From: [REDACTED]
Sent: 11 June 2018 09:43
To: Planning.Responses
Subject: RE: Planning Consultation on: BN/17/18/HH

APPLICATION NO: BN/17/18/HH
Registered: 17th April
2018
Site Address: 2 Mill Cottages Yapton Road Barnham PO22 0BG

Description of Works: Studio in rear garden.

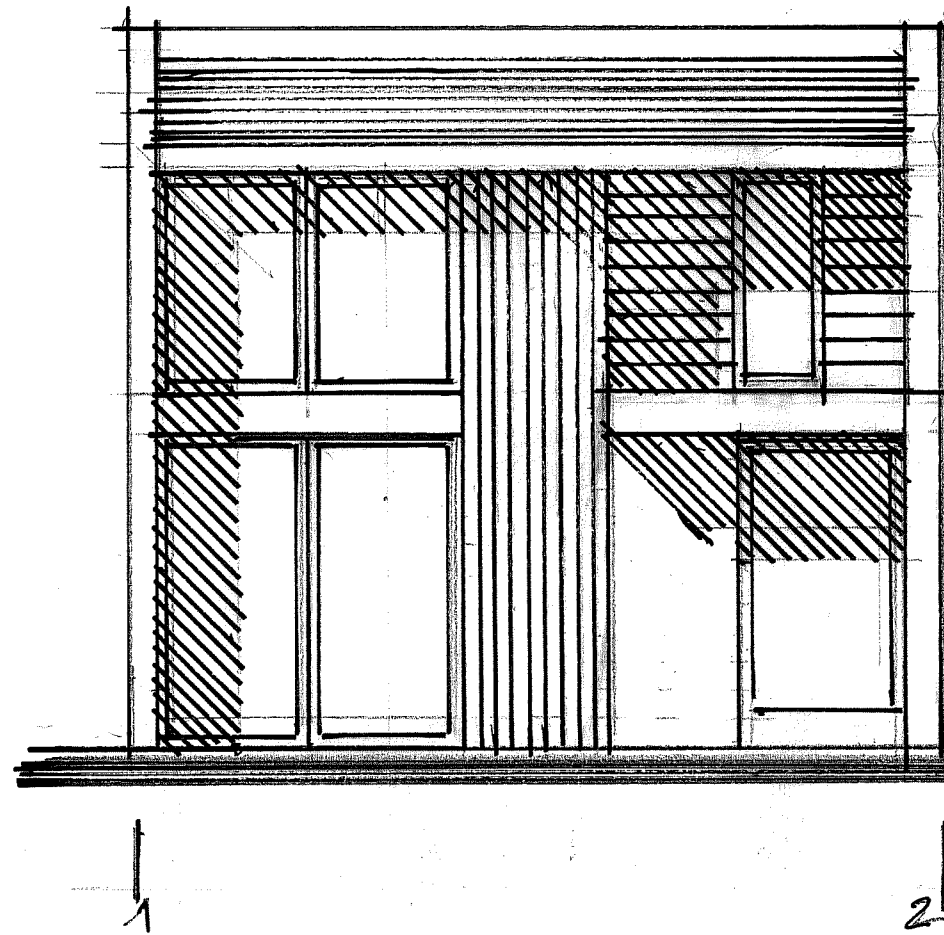
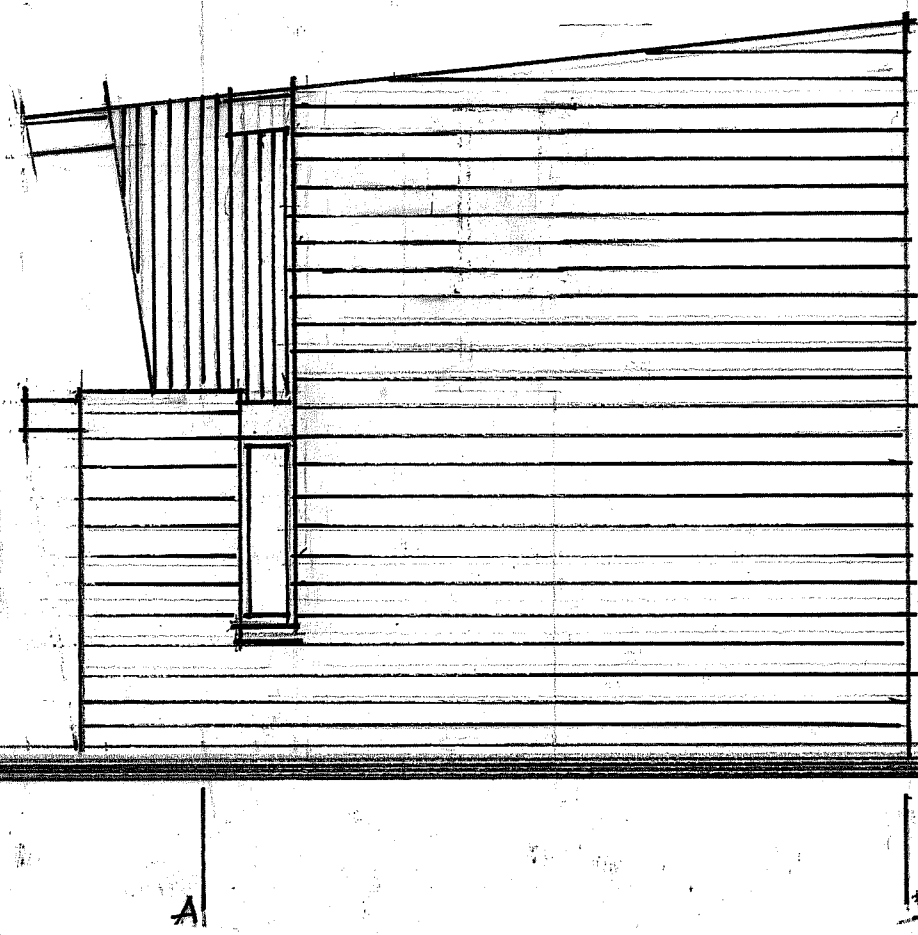
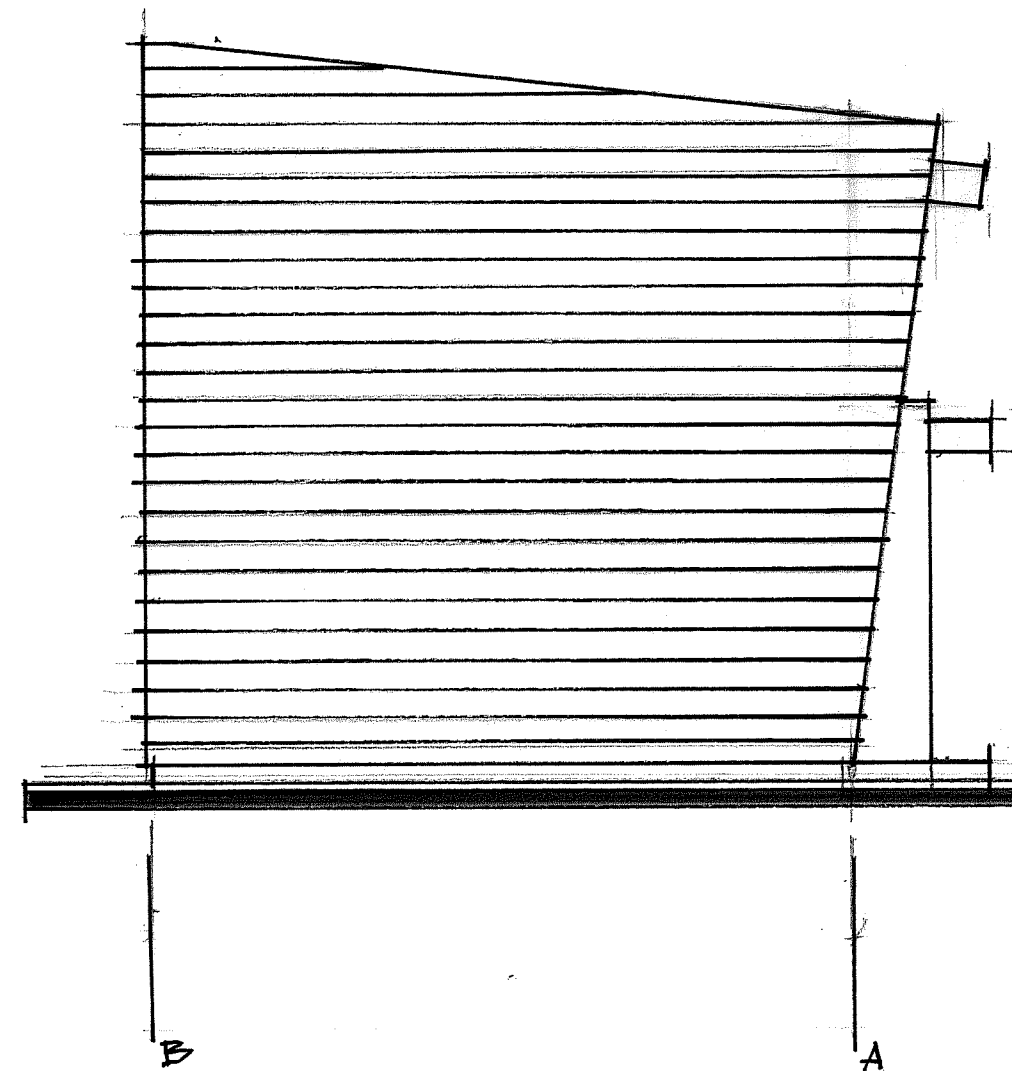
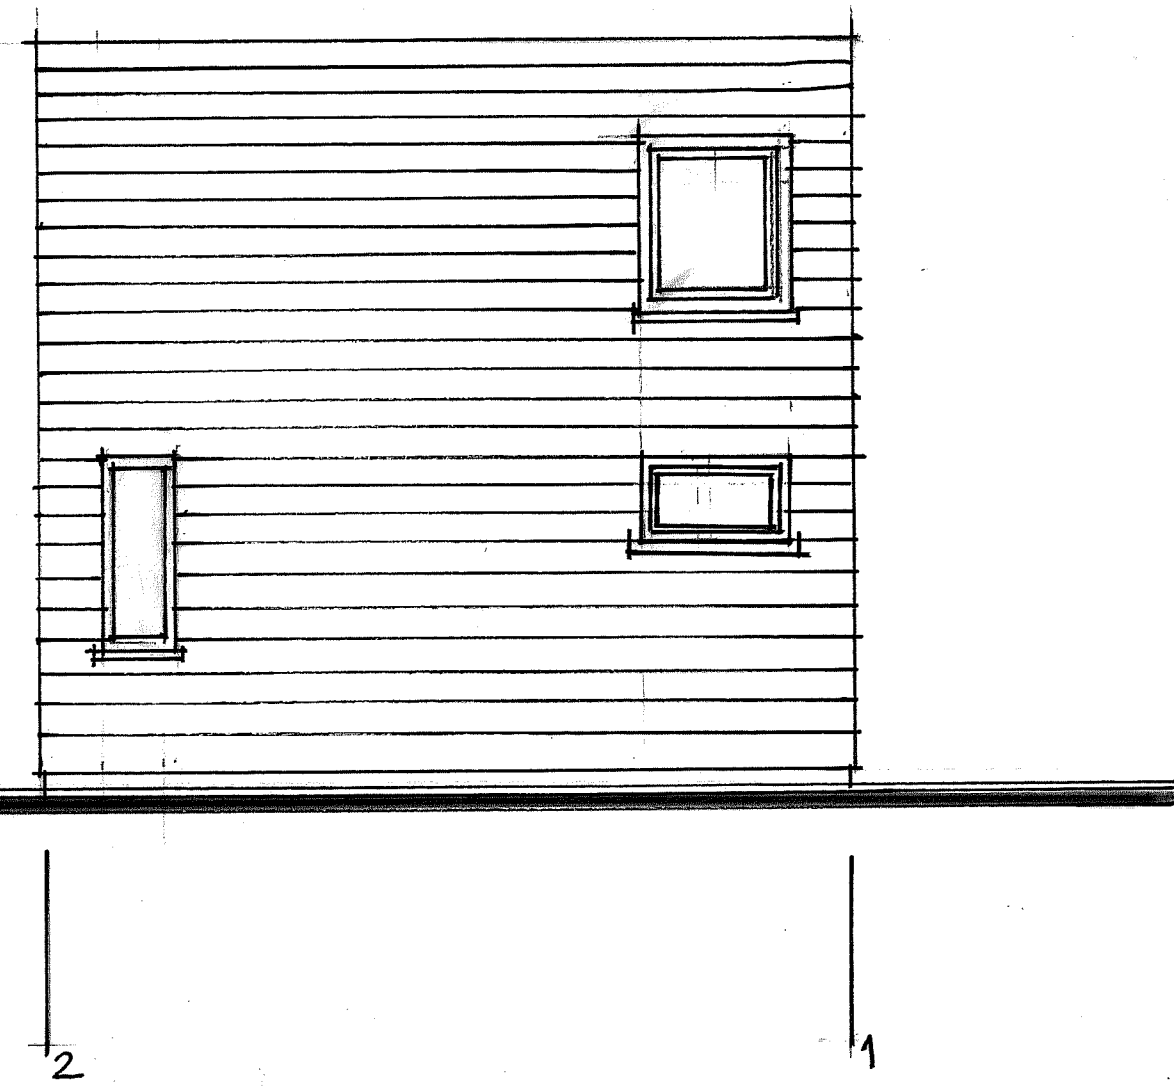
Whilst the Council does not wish to formally object to the application they would like to comment on the height of the building which appears to be rather high (at the high side of the design_ and also to comment that they would wish to see a condition that will ensure that at no point in the future will the building be converted for permanent use. The Council was also surprised that such an application was being submitted as the garden already has a large summer house in it.
